BEACON FEN

ENERGY PARK

Statement of Common Ground (Final) with North Kesteven District Council
Document Reference: 8.2
February 2026

Soil Stockpile Design

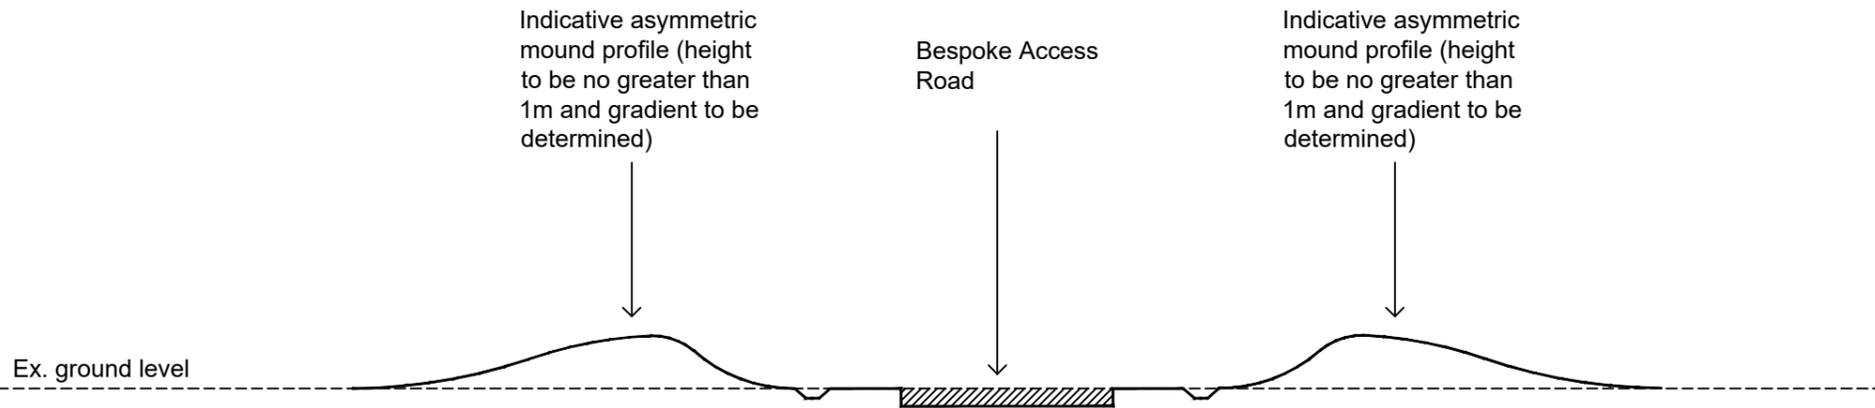
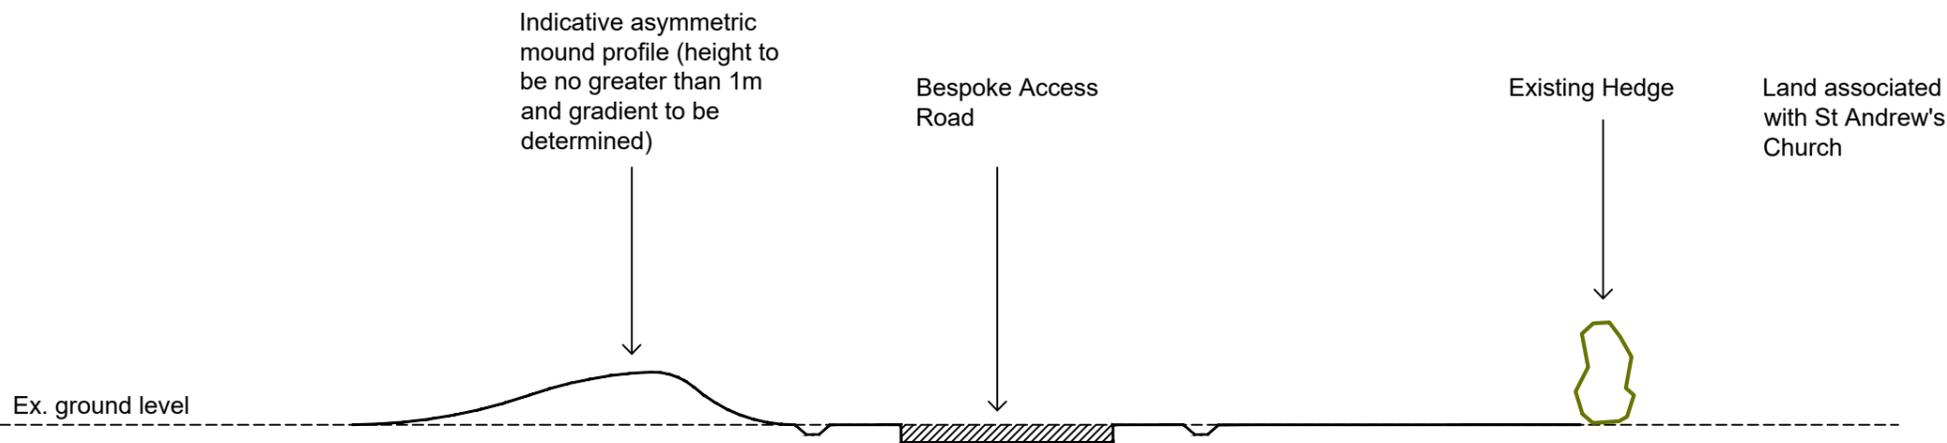
Soil Stockpiles within the BAR:
